17 December 2025

Document Set ID 1386557
Contact: Bryce Weedon

**Hilltops Councils Submission
SSD-6698-Mod-2 - Modification 2 Decentralised BESS
Yass Valley (Coppabella) Wind Farm**

APPENDIX 7
BESS LOCATIONS

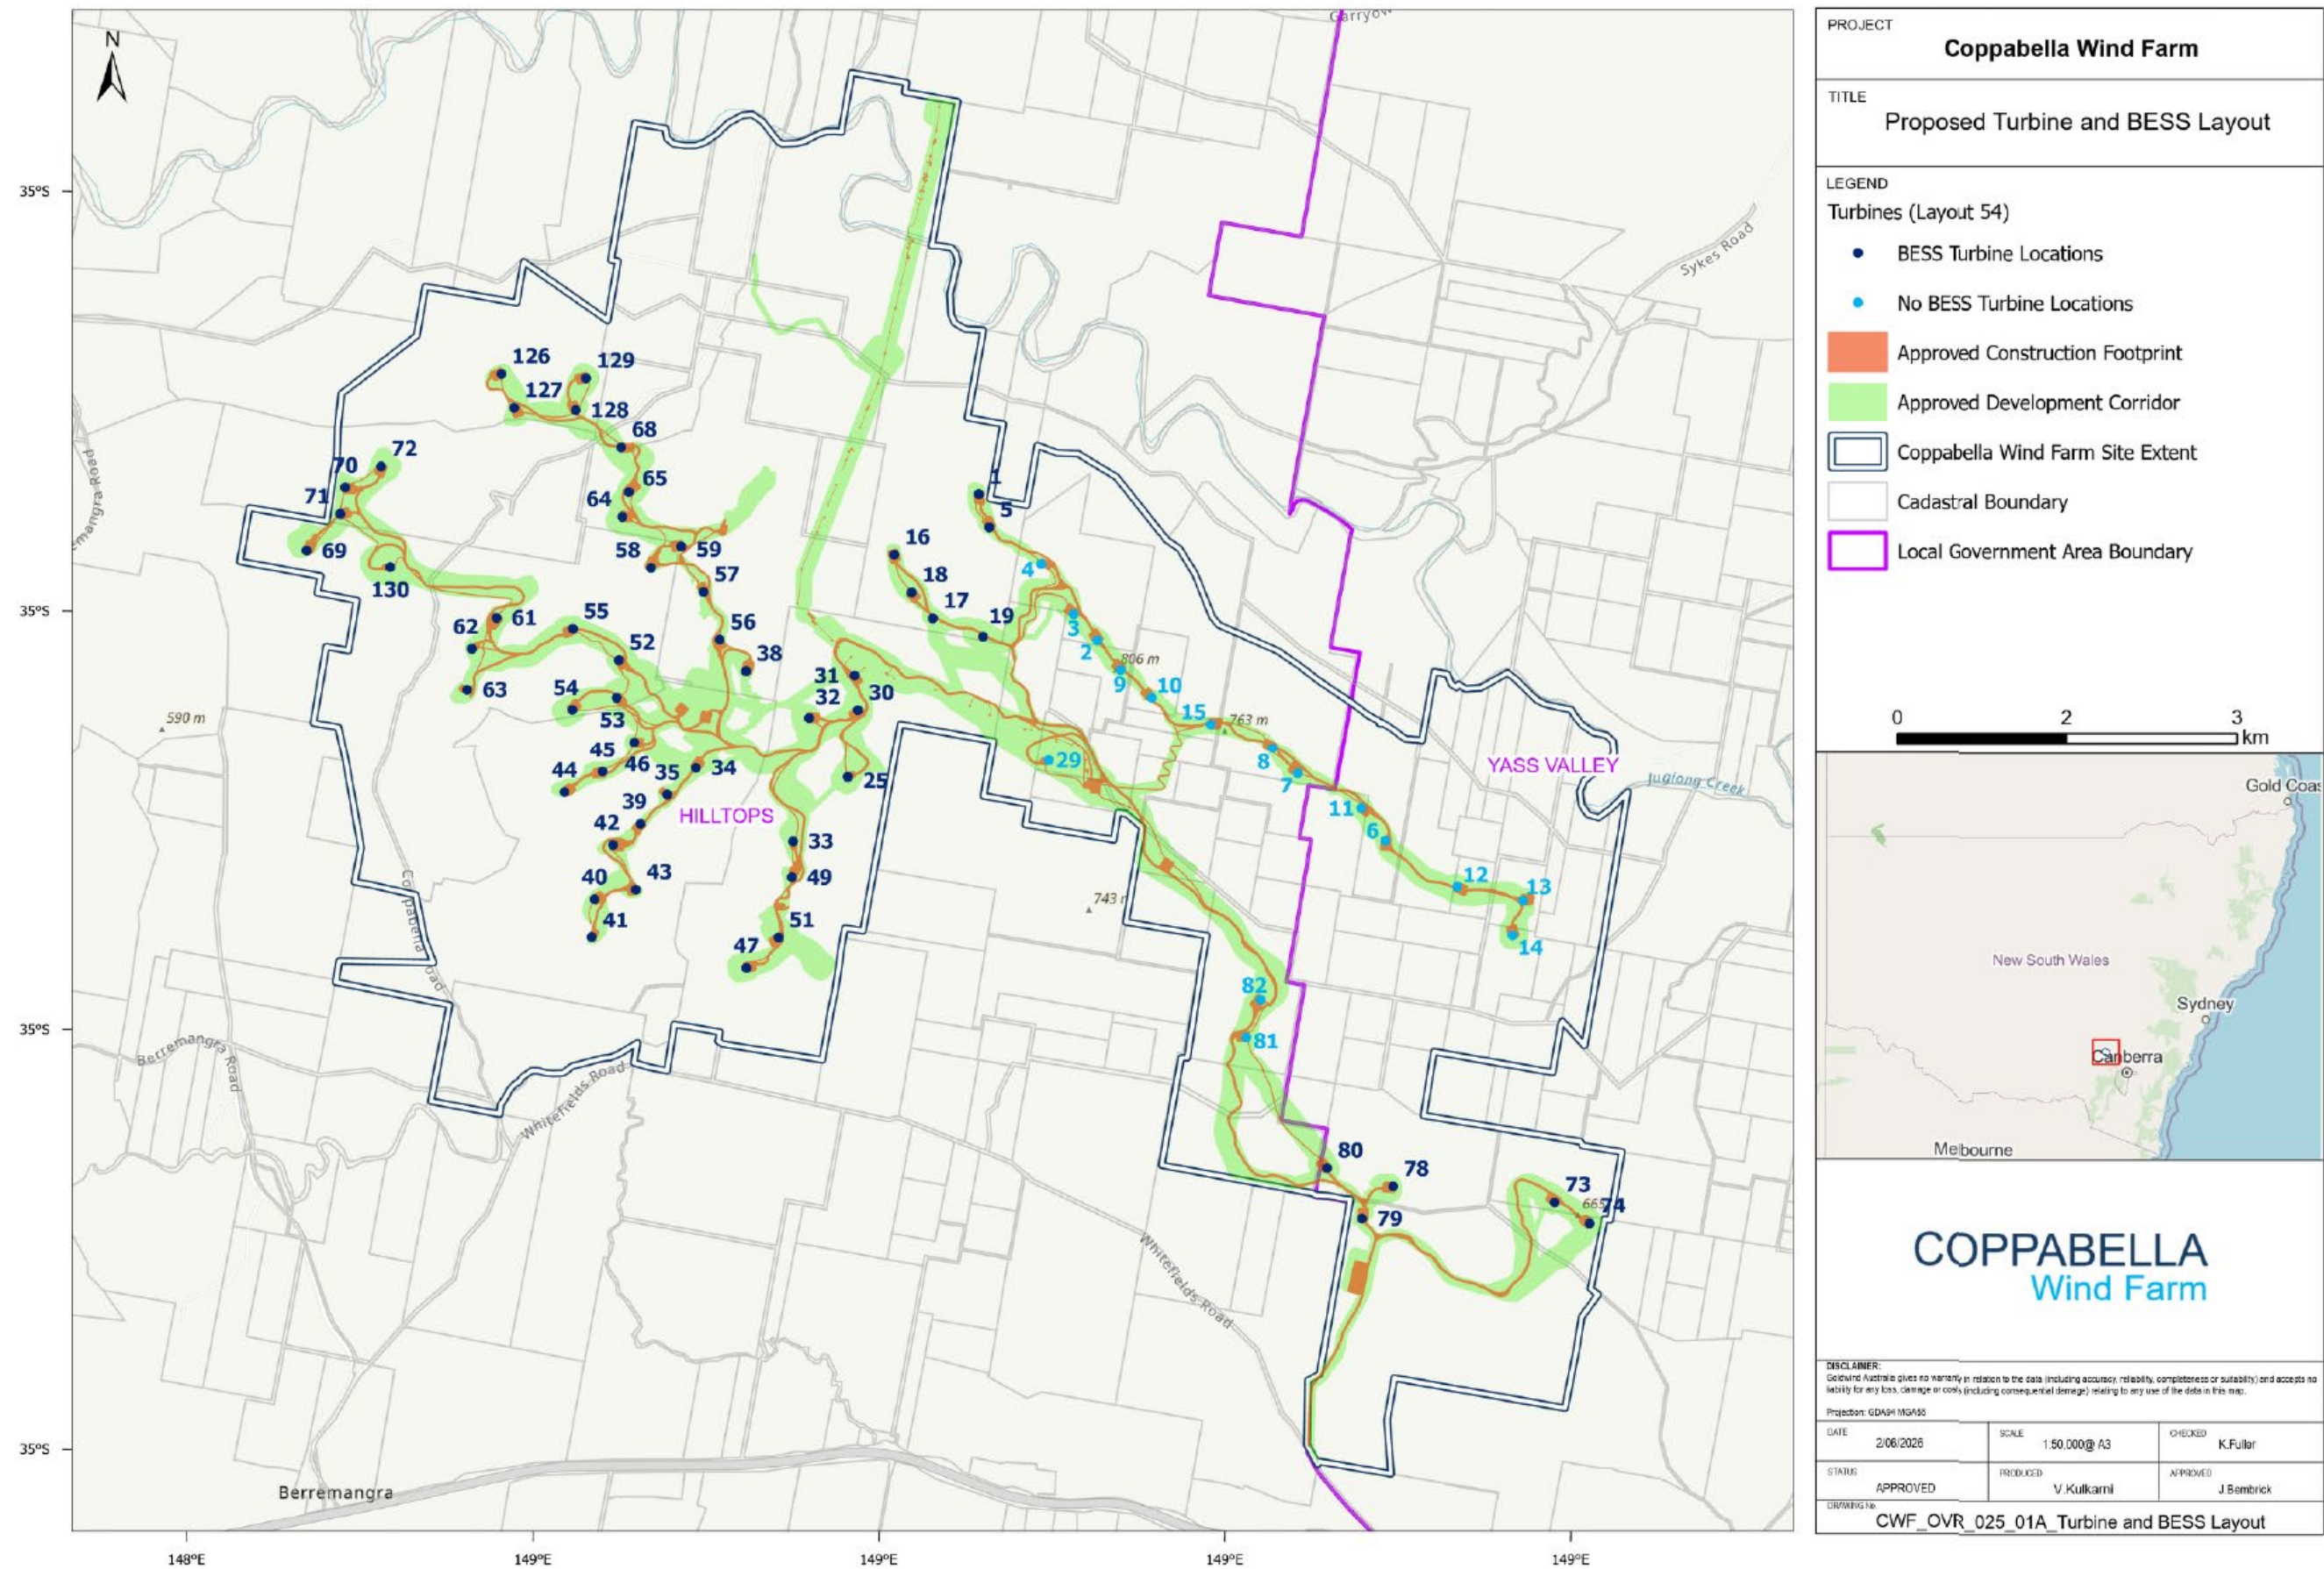
The location of the proposed BESS is not clearly mapped or identified. The Project Site and Project Area Map (Figure 2.1) do not identify which Wind Turbines will be co-located with a BESS nor does the Indicative Layout (Section 3.2) include the location of the BESS and their associated wind turbines.

Without the determined locations of the proposed 53 BESS, the Application is insufficient in identifying, assessing and potentially having mitigating treatments for each individual BESS their individual locations and in association with the approved Wind Turbine.

At no point in the Application are the individual locations of the 53 BESS identified or mapped. The Bushfire assessment notes that: *A defendable space of at least 24-40m will be provided around the footprint of each BESS to avoid flame zone (FZ) contact (Table 6.1 Page 274)*. Indicatively the Wind turbines are within 10m of the location on the BESS.

Council is seeking clarification from the Applicant on the individual location of the 53 BESS.
